Dear Simon,

many thanks for sending over the existing and proposed drawings of your property, as well as the sunlight study you have undertaken.

PROPOSED SIDE ELEVATION C/C
SCALE 1:50

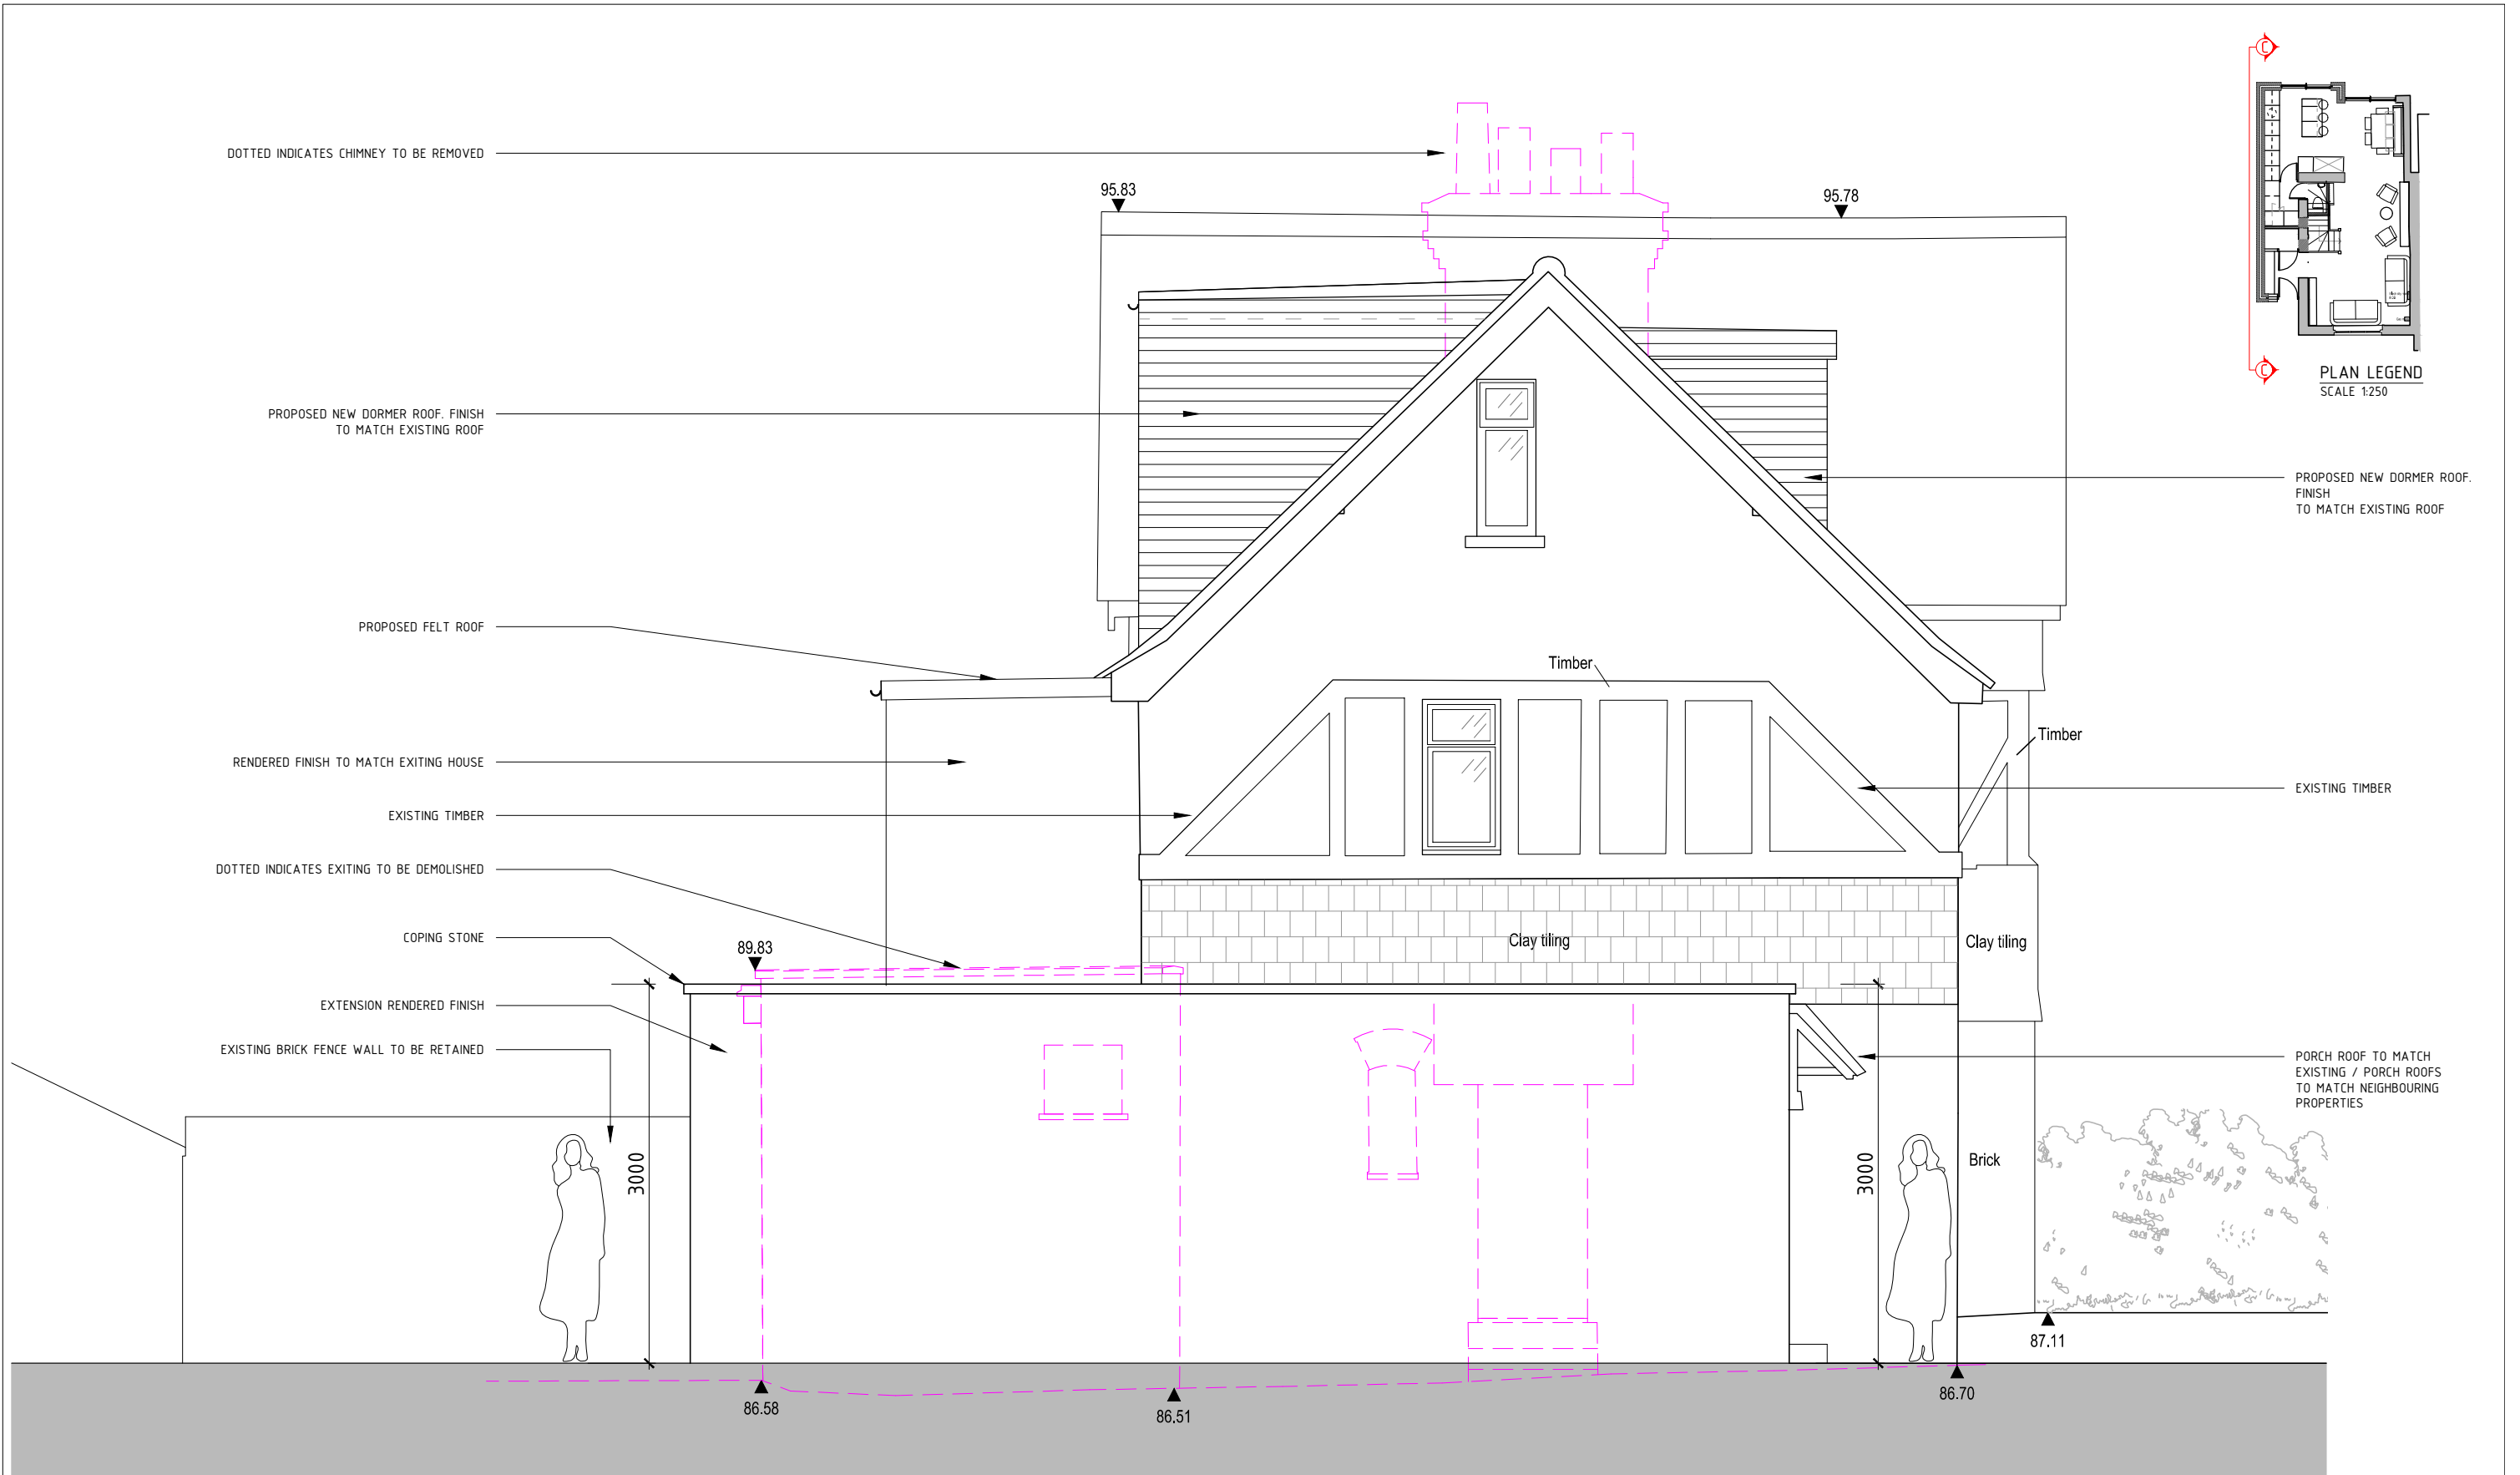
The BRE guidelines highlight that only habitable rooms are a material consideration, with room uses such as hallways, stairs and bathrooms not requiring assessment. Therefore, when looking at your neighbours property at No.8, the ground floor windows/rooms would not be tested for daylight/sunlight, as they serve a hallway and bathroom. At first floor level, the side window to No.8 serves the stairs, so again would not be considered. The second floor side windows lights a bedroom, but with the additional dormer window facing on to the front light the same room, there would be no light reduction.
